Request for Clarification of Information

Address: 38 Pamela Road

Permit #: 2017-00131

Date: 3/7/2017

Amended A4
38 Pamela Rd

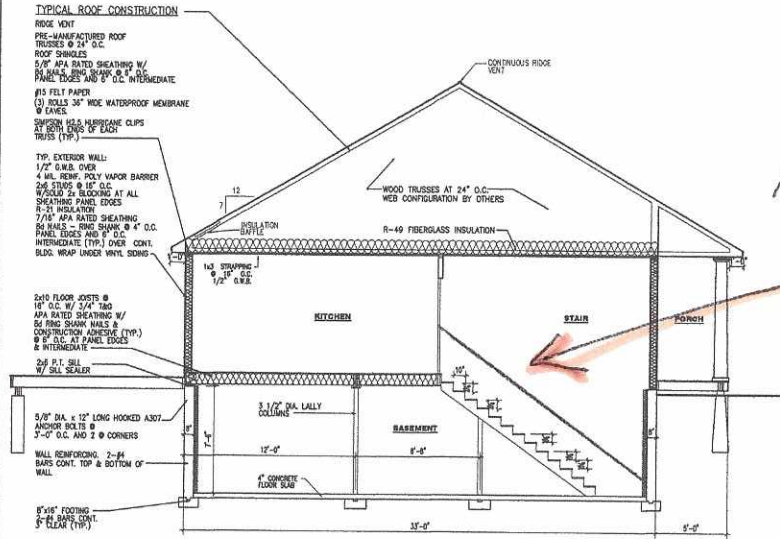
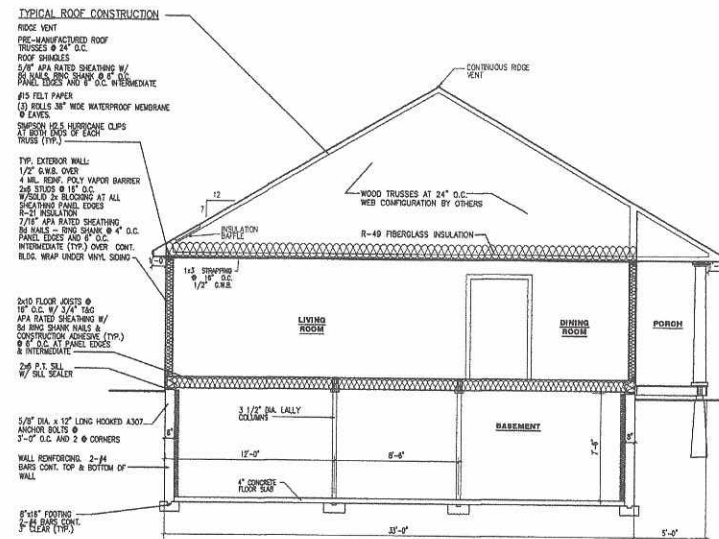
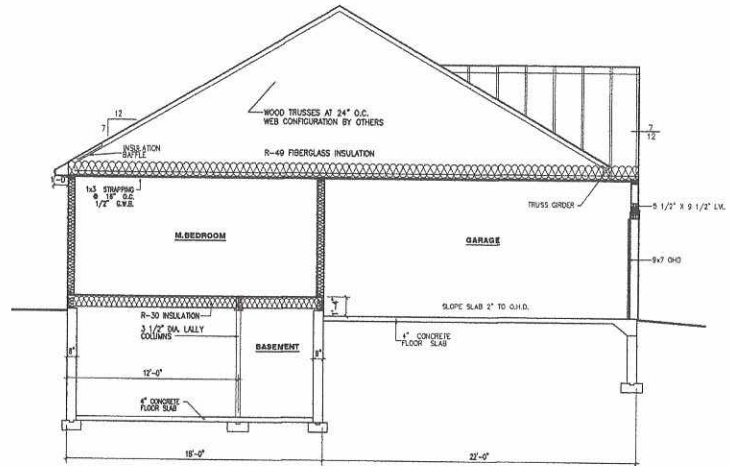
8. Show height of handrail in section: **See attached amended plan**
9. Show location of CO and smoke detectors and specify requirements . **Per plan page A1**

5. Provide more specific information on the roof covering. **Certainteed architectural Landmark Lifetime**
6. Provide connection and structural details for the Deck construction . **per plan page A0 deck / joist detail**

38 Pamela Rd
Amended Floorplan
A1

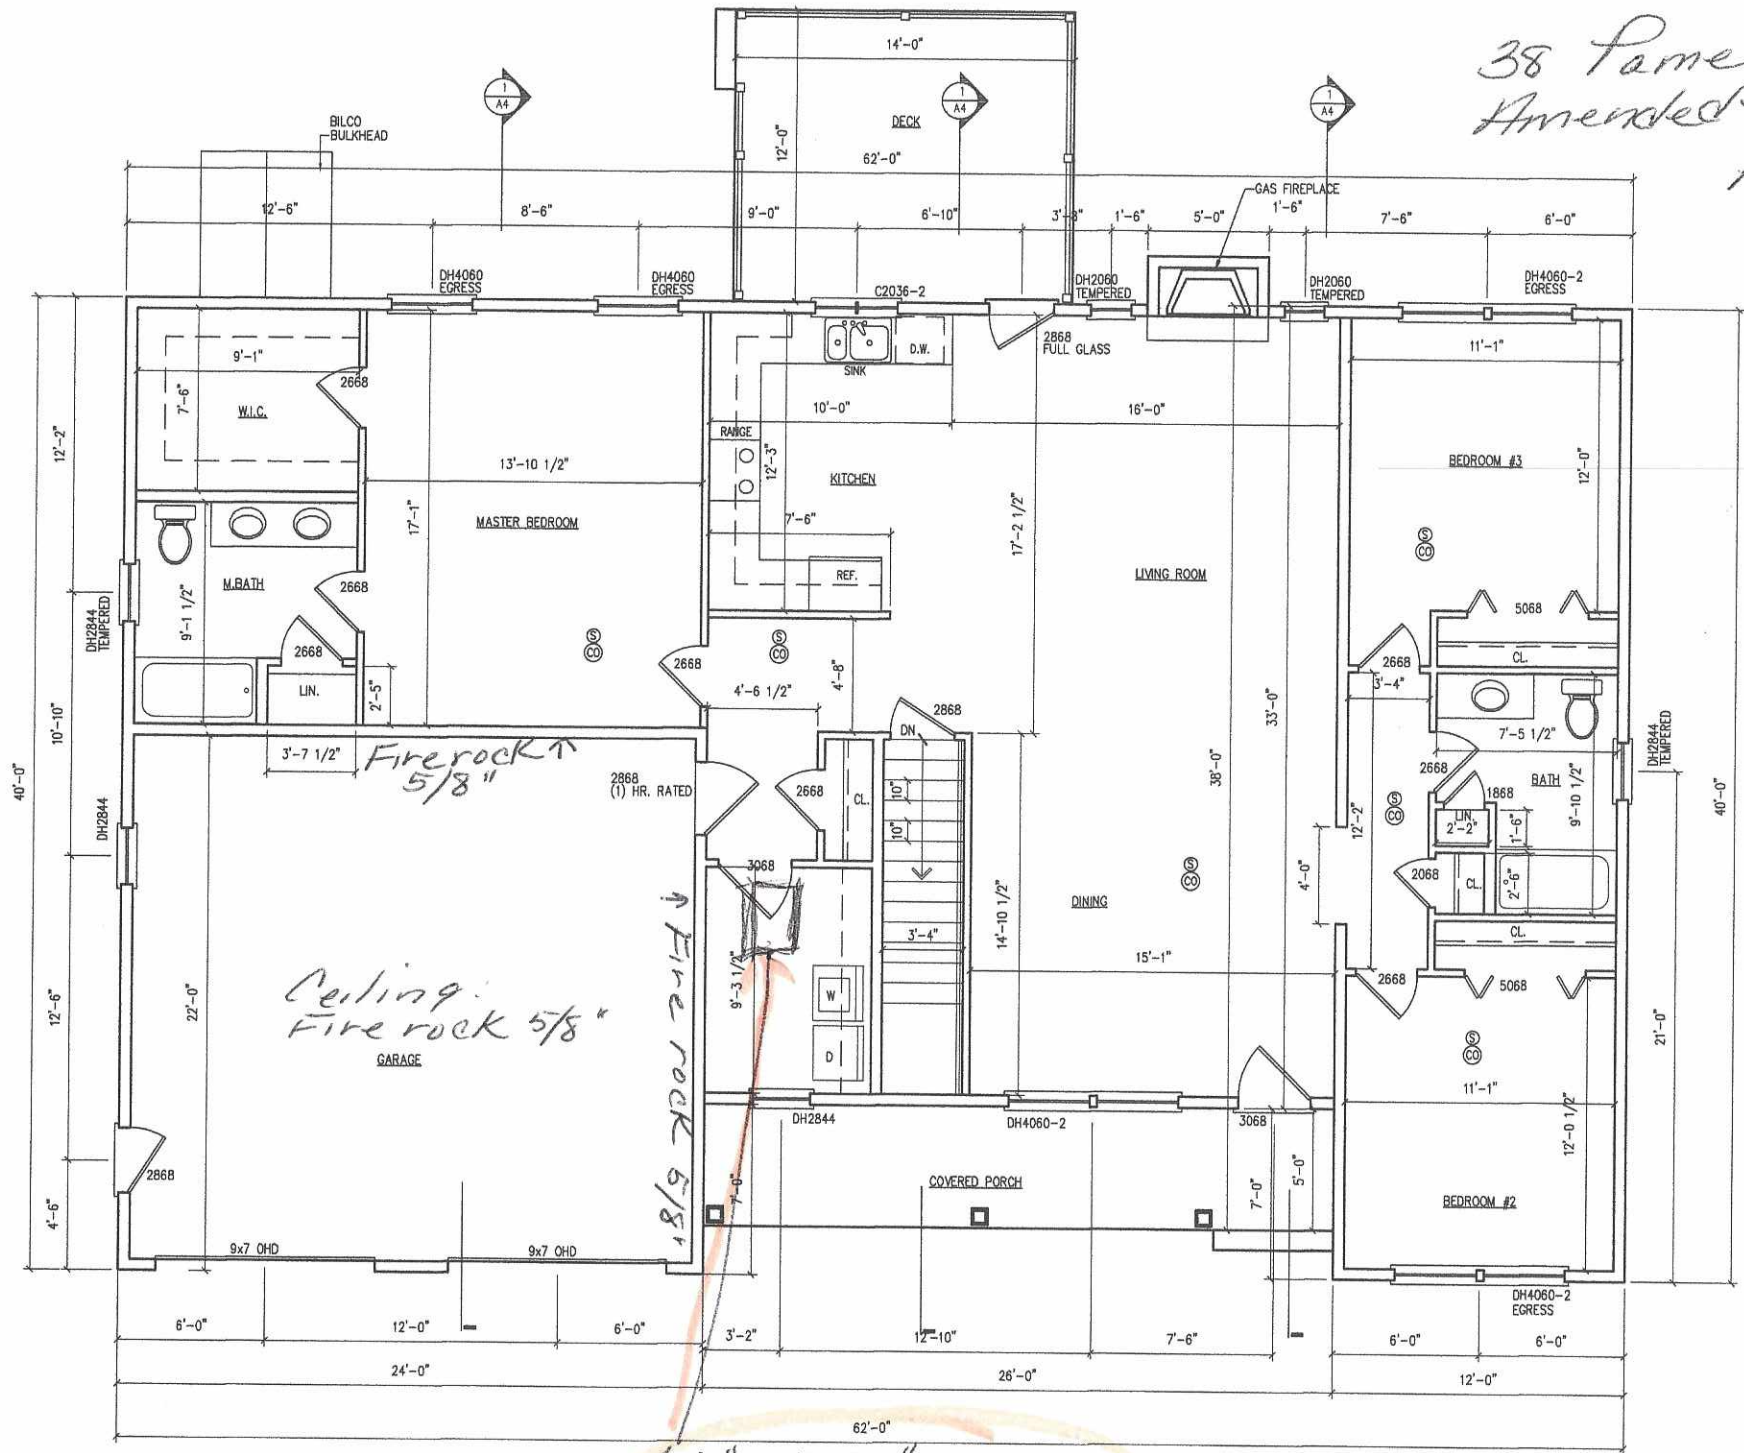
11. Show the location and the size of the access to the attic : **See amended plan attached - 22" x 30" access in laundry room ceiling**
12. Provide details for chimney clearance and fire blocking: **N/A**
